Epping to Thornleigh Third Track Proposal. Application number SSI 5132.

I/we object to the Epping to Thornleigh Third Track Proposal and consider that the EIS is inadequate and does not address the full impact of this proposal. It will cause untold damage to the health of residents and to the fabric of the Beecroft Cheltenham Heritage Conservation Area. Do not approve this project, reconsider the alternatives and protect the community.

Figure S.6 Cross-section and elevation - New Cheltenham Station concourse building (see also S.5 for artist's impression)

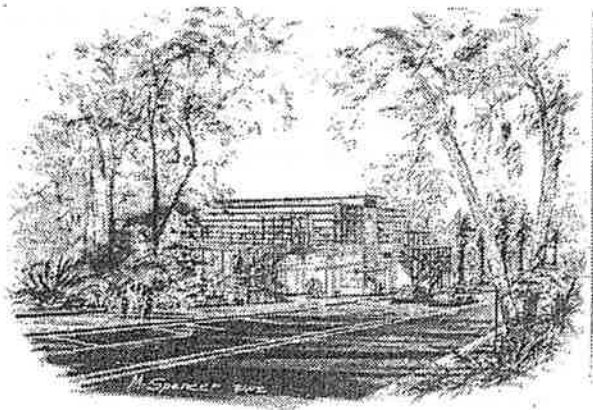
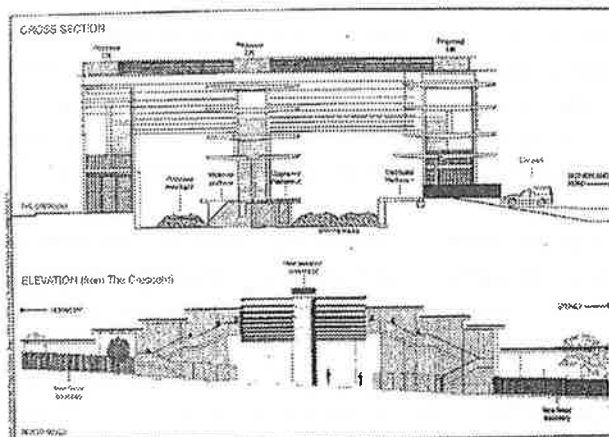
- The proposed redevelopment of Cheltenham Station shows no regard for the HCA. The visual impact of the proposed 13m high glass and steel concourse is totally unacceptable in this HCA.
